John Wheatley Architecture
56 Maltravers Street
Arundel
BN18 9BQ

Please ask for: Ms Iqraa Malik
Email: iqraa.malik@terraquest.co.uk
Telephone: 01212341390
Our Ref: AB/19/21/HH
Your Ref:
Date: 26th February 2021

Application for Planning Permission for Works or Extension to a Dwelling

Location: 32 Maltravers Street Arundel BN18 9BU

project:	32 Maltravers Street - Arundel - BN18 9BU		
drawing title:	Existing and Proposed Site & Roof Plans		
drawing status:	Planning Application Proposals		
date:	18 - 02 - 2021	scale at A3 original size	1: 200
no:	JW2012ARU - PL03	rev:	B

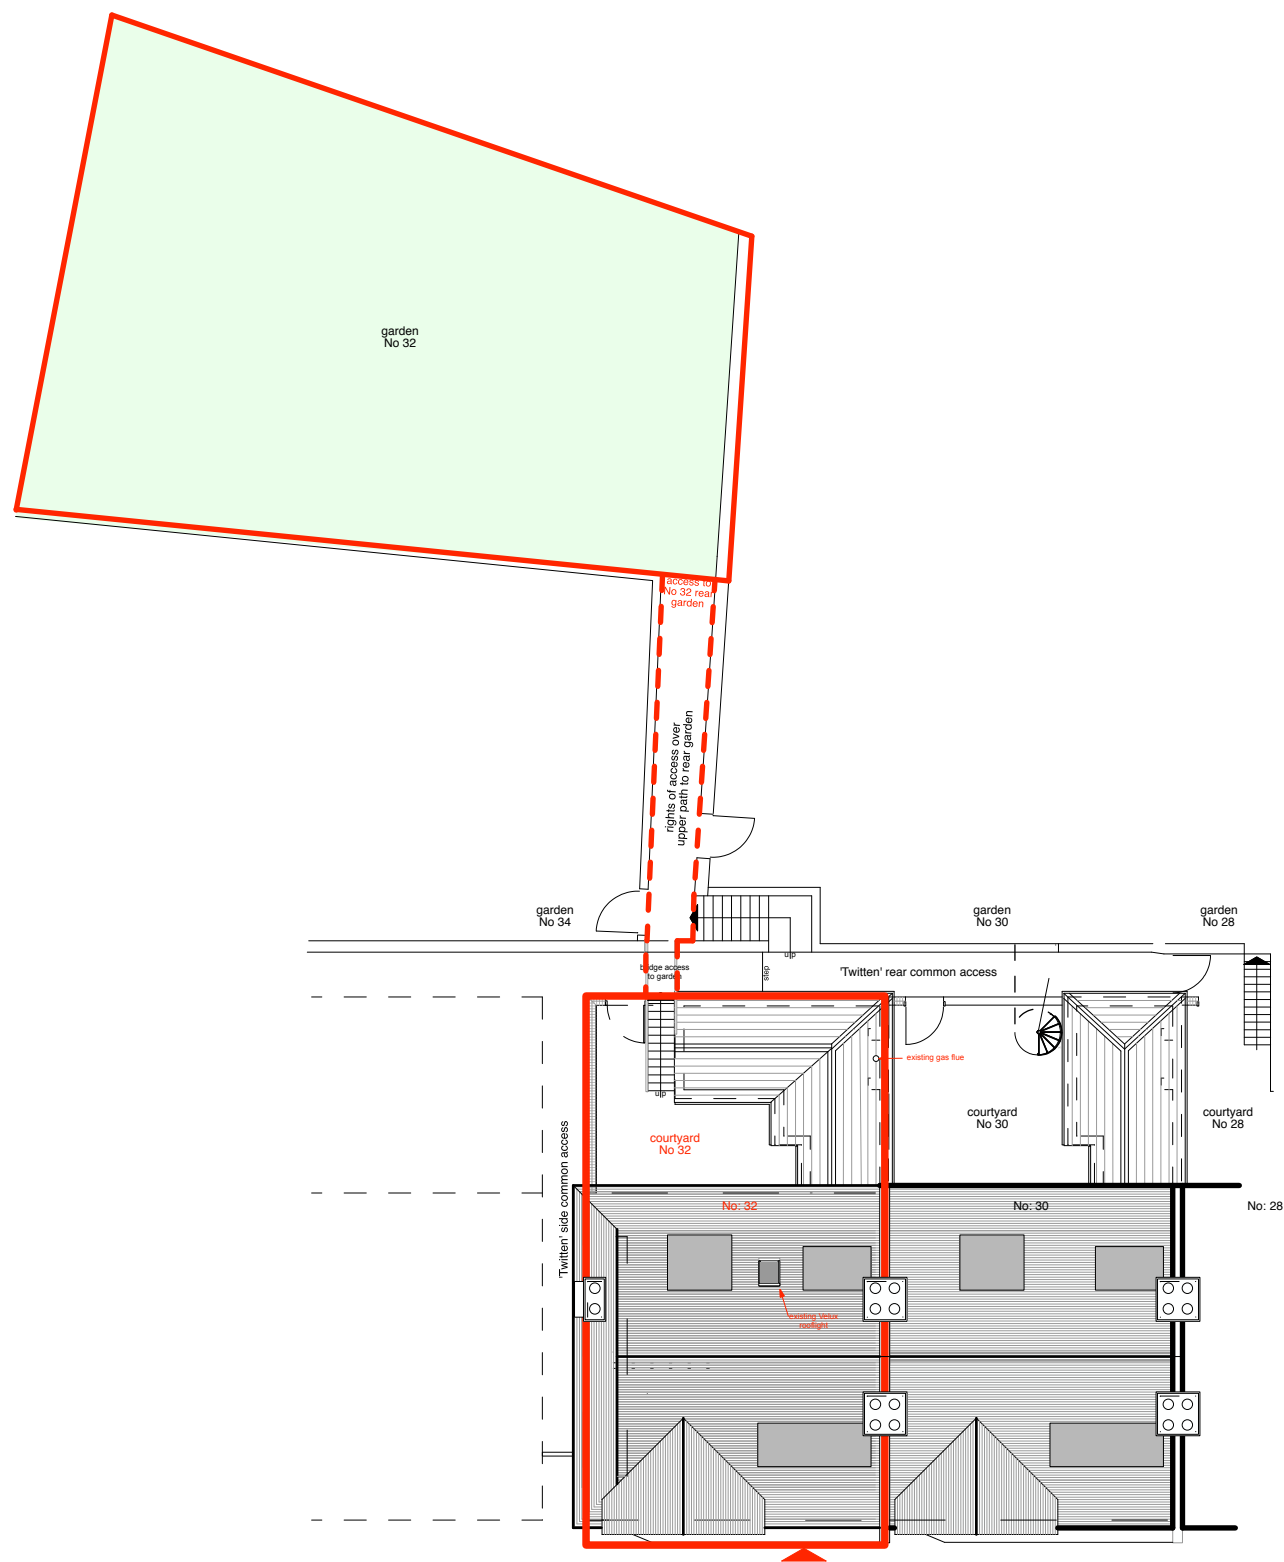
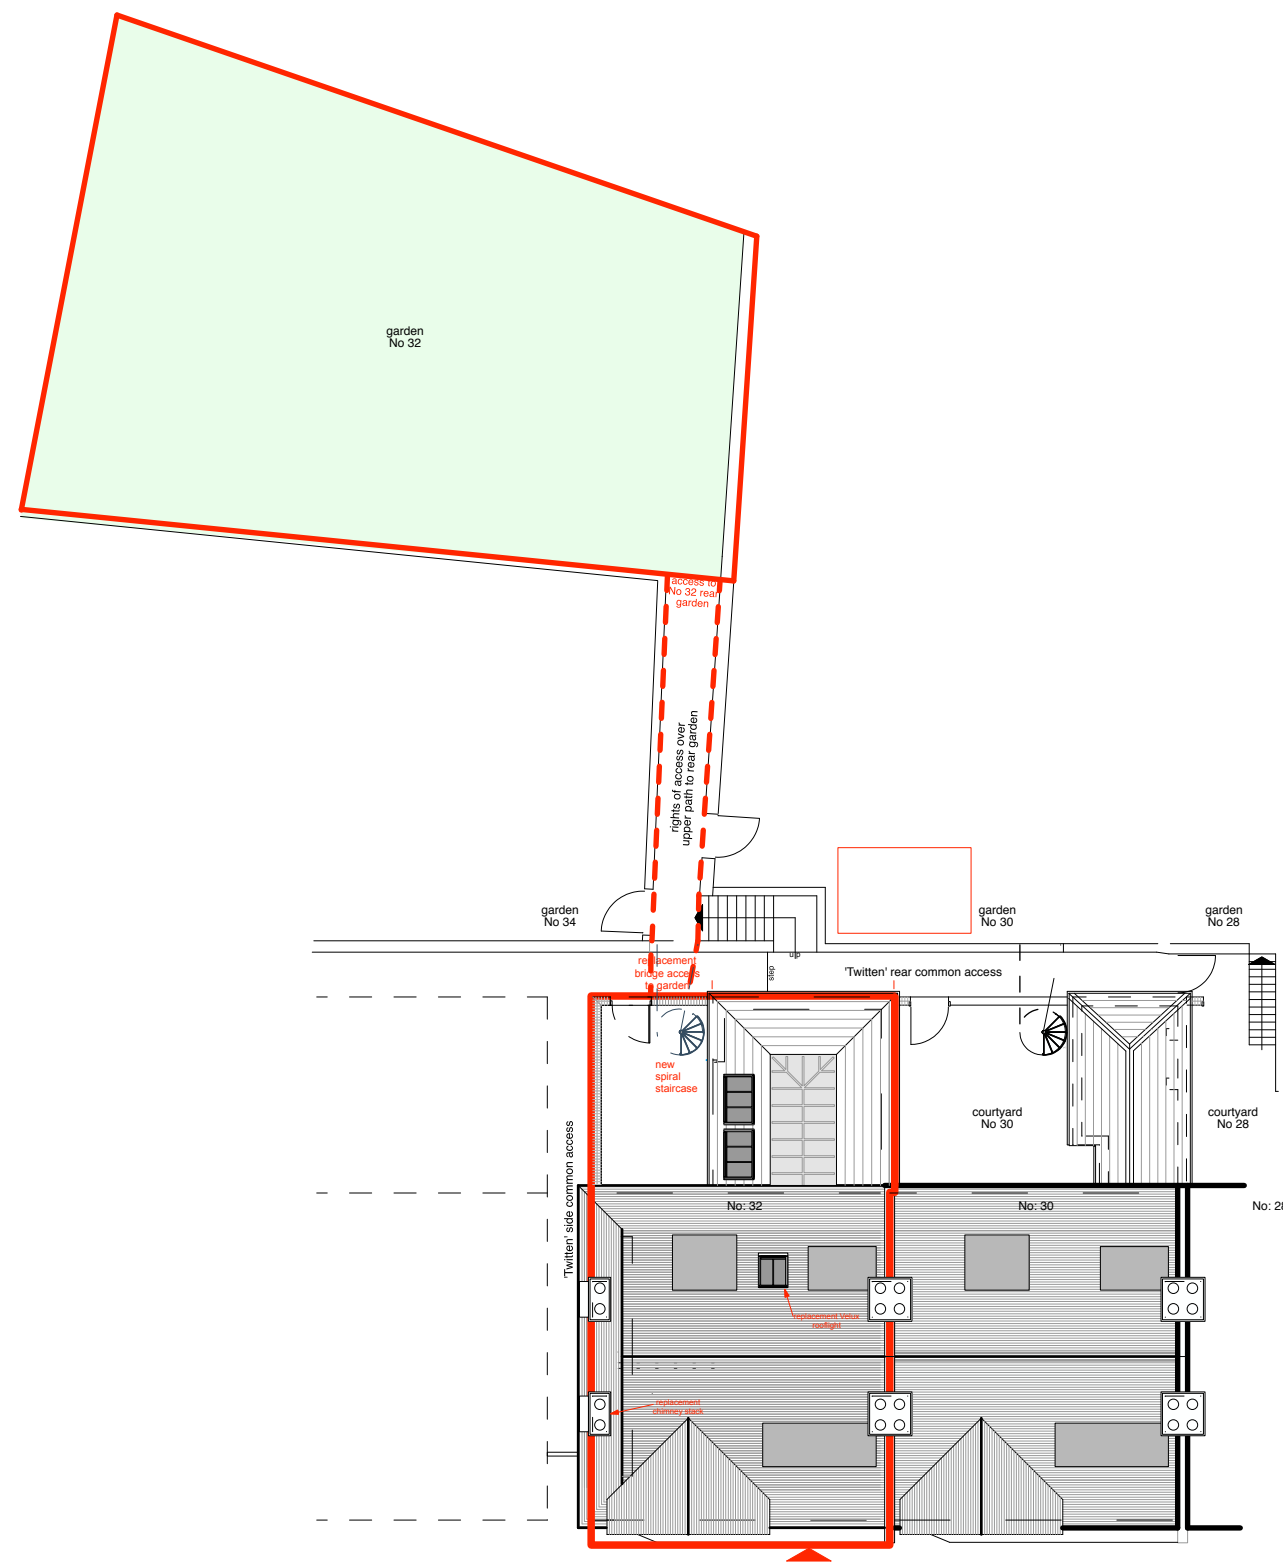
Dimensions: You are required to include dimensions from the proposed extensions to all site boundaries.

**Development at 32 Maltravers Street Arundel BN18 9BU
PL01B - Location Plan at 1:1250 scale (A4)**

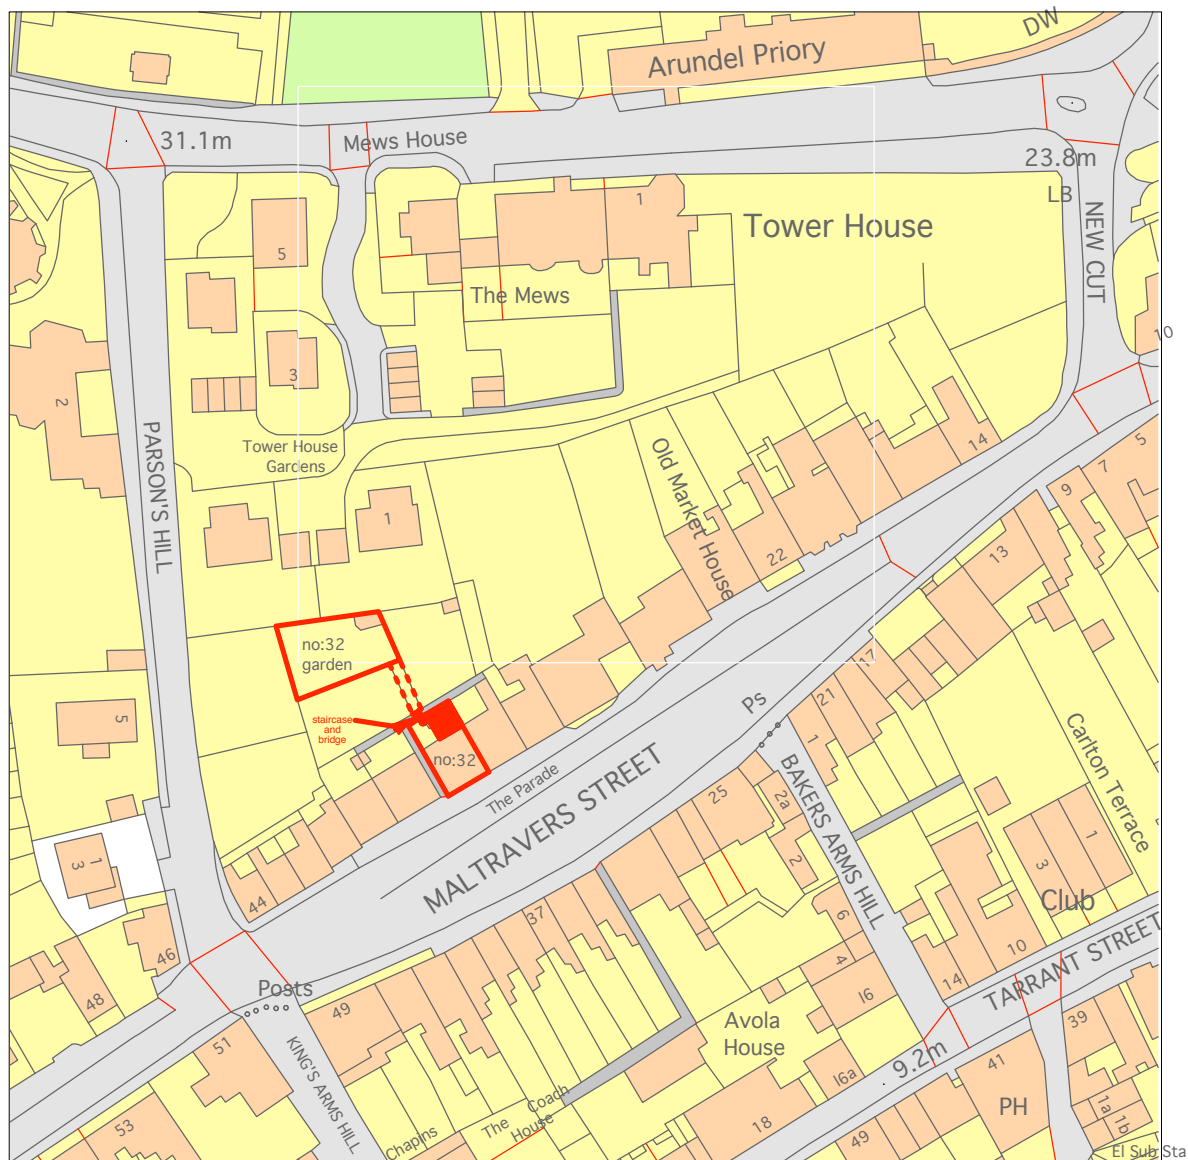
Location Plan: You are required to only include the proposed site in the red outline on the location plan. Please remove all other red outlines
